Proj. Name: OCH Friel-Chapel - 200 Beausoleil Drive
Updated: July 19, 2023

ZBLA + SPCA - 200 and 201 Friel Street - Second Review Comments

LANDSCAPE PLAN

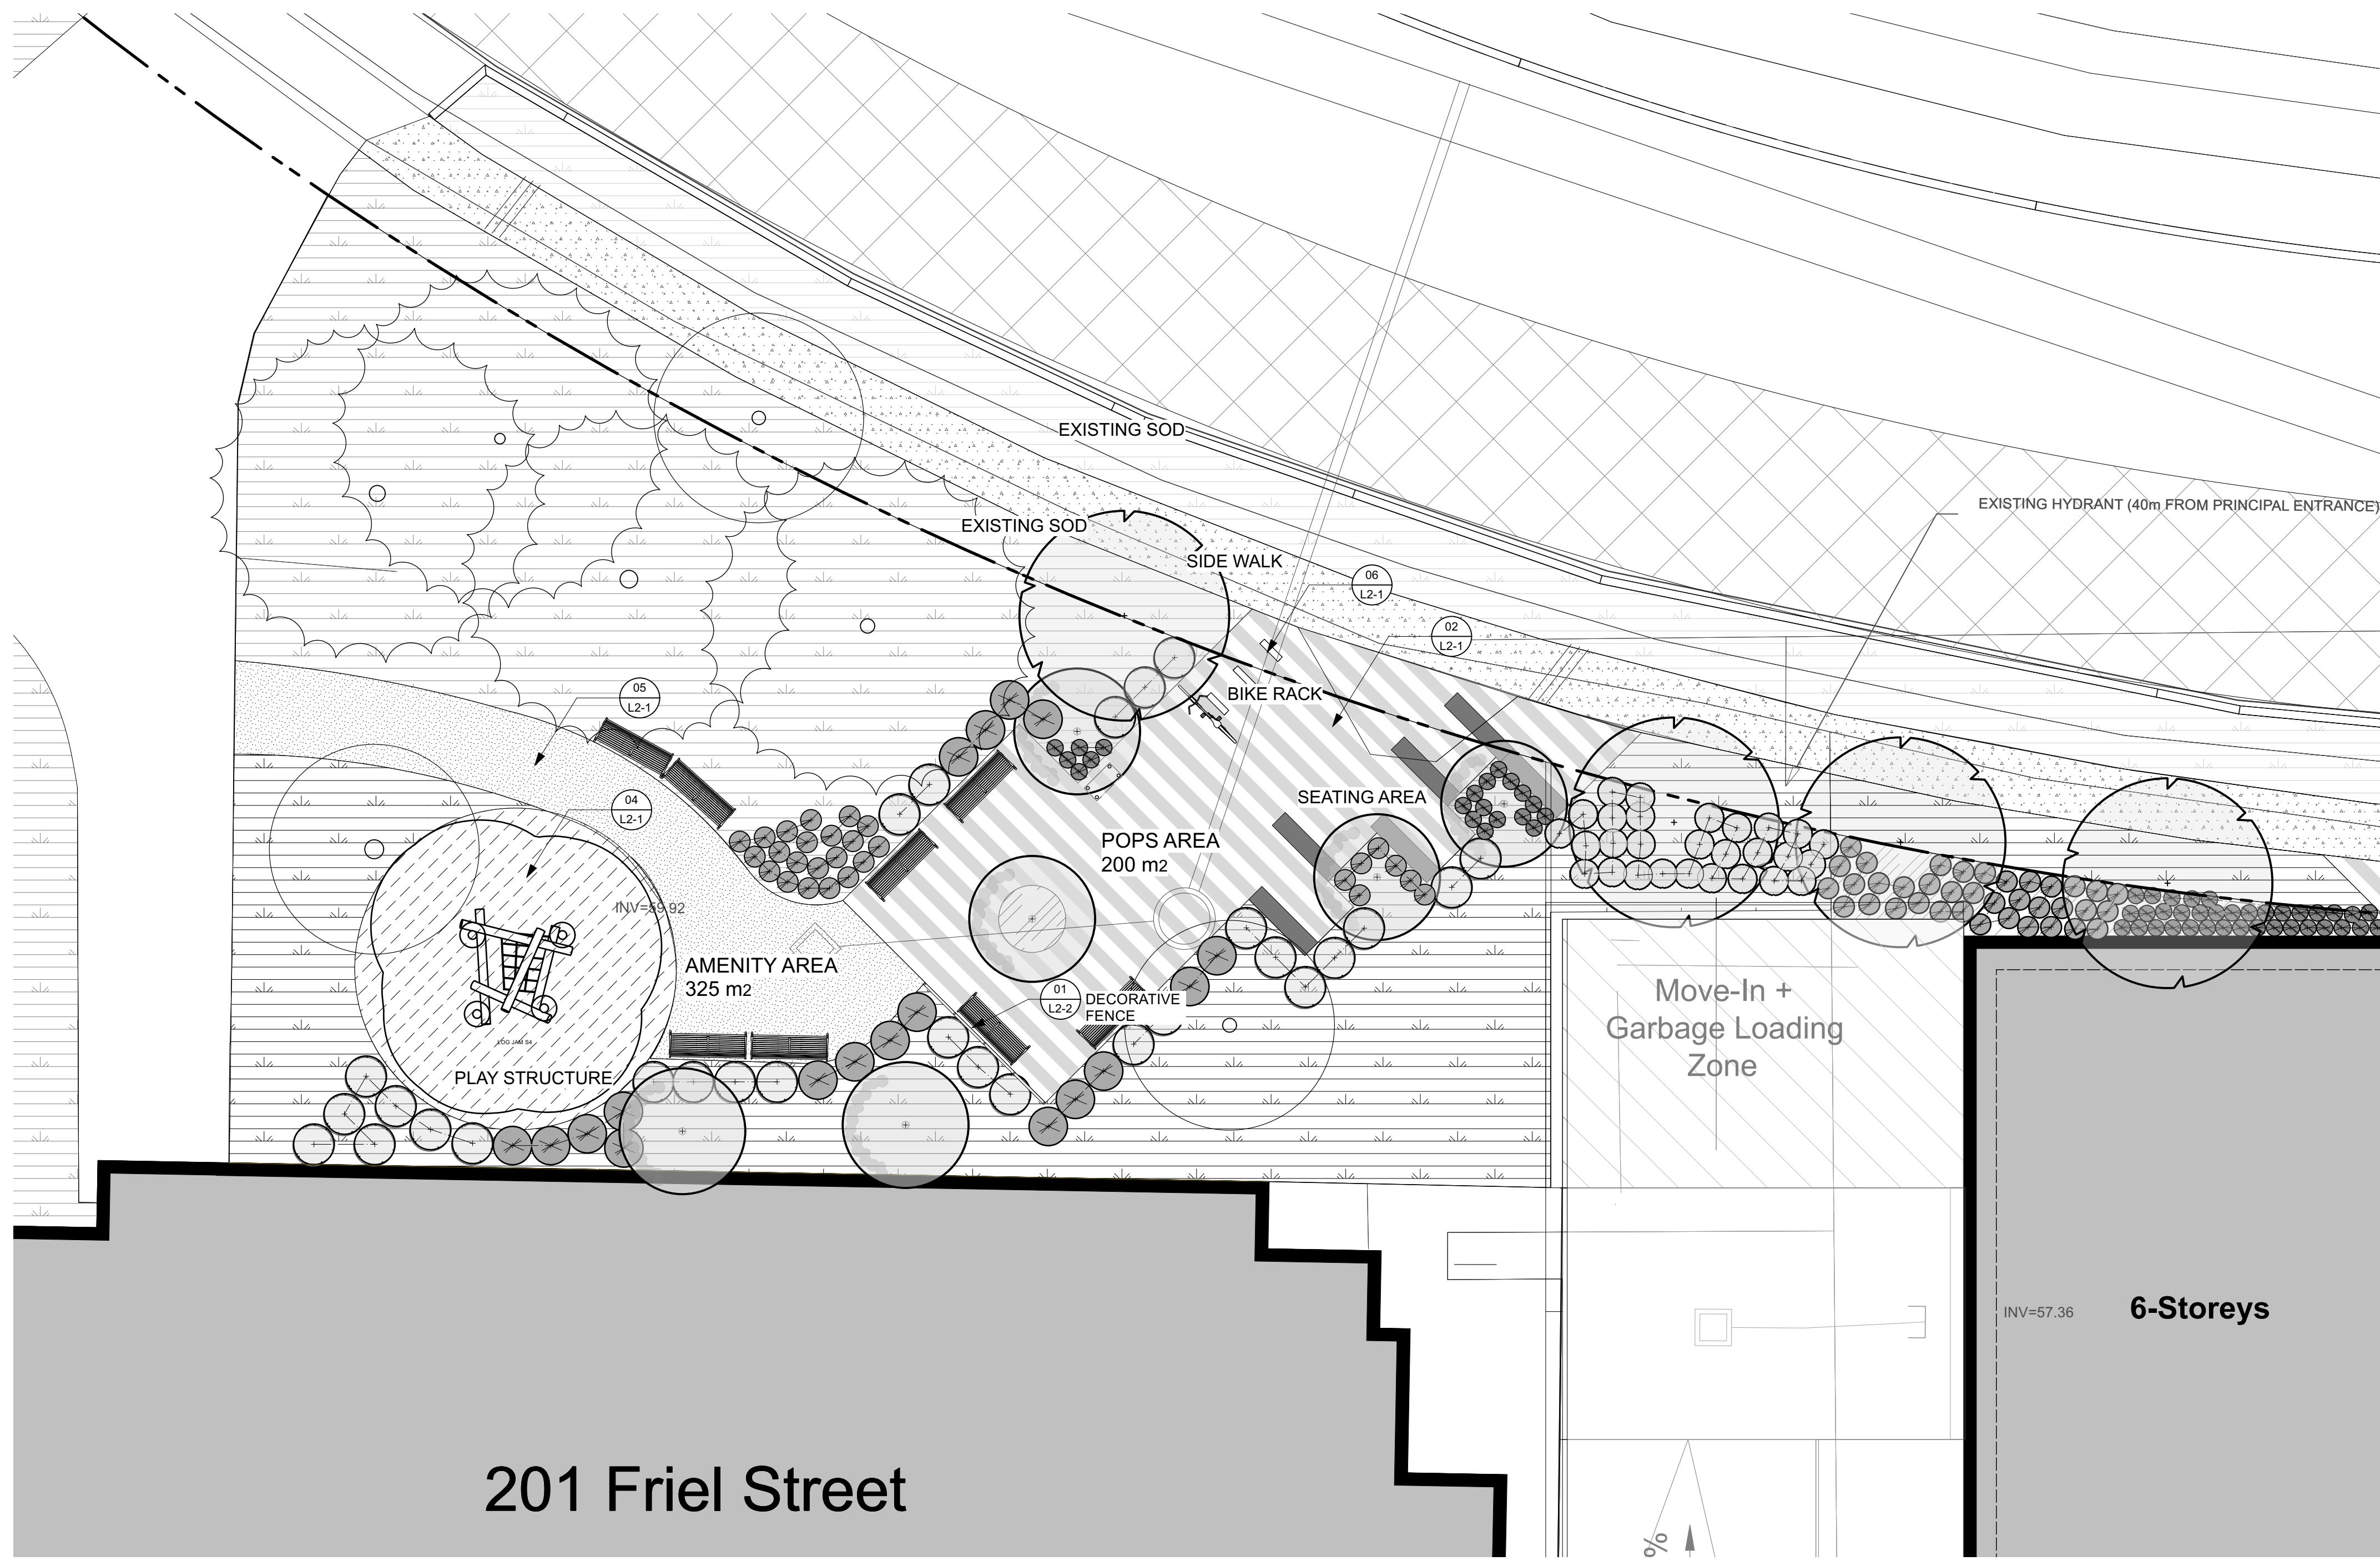
2.25	On the Beausoleil Drive frontage, directly in front of the fire department connection (northeast corner of the building), the landscape plan notes a new TWSI located between the sidewalk and the road. It is assumed that the TWSI is part of a curb ramp designed to support the "OC Paratranspo Pick-Up/Drop-Off" space noted in the site plan. However, the TWSI location and curb ramp design are atypical. The TWSI should be adjacent to the curb edge not adjacent to the sidewalk. Provide more discussion and design detail on this TWSI and possible curb ramp. For an accessible passenger loading zone, consider design guidance from Section 3.2 and Figure 28 of the City of Ottawa Accessibility Design Standards. If enough space is not available for an accessible access aisle, discuss with Transit Services staff and consider a curb ramp similar to City of Ottawa standard detail SC12.4 (attached).	Architectural / Landscape / Civil	MH / Lashley / DSA-KWC	Please see detail 1 on drawing C002 - Grading Plan, prepared by Morrison Hershfield, dated July 13th, 2023 for detail at Paratranspo Loading Zone, including TWSI location and extents.

4.18	Thank you for additional information added to landscape plans. For the POPS design, please add a waste/recycle bin, lighting, and electrical source, as per the Community Design Plan guidance. It appears like part of the site furniture exists on the Beausoleil Right-of-Way. Please ensure anything outside of pavers and landscaping is located on the private property to avoid the need for an encroachment agreement.	Landscape	Lashley	Please see revised drawing L1-02 - Landscape Plan-POPS, prepared by Lashley + Associates, dated July 12th, 2023, addressing and incorporating the noted comments.
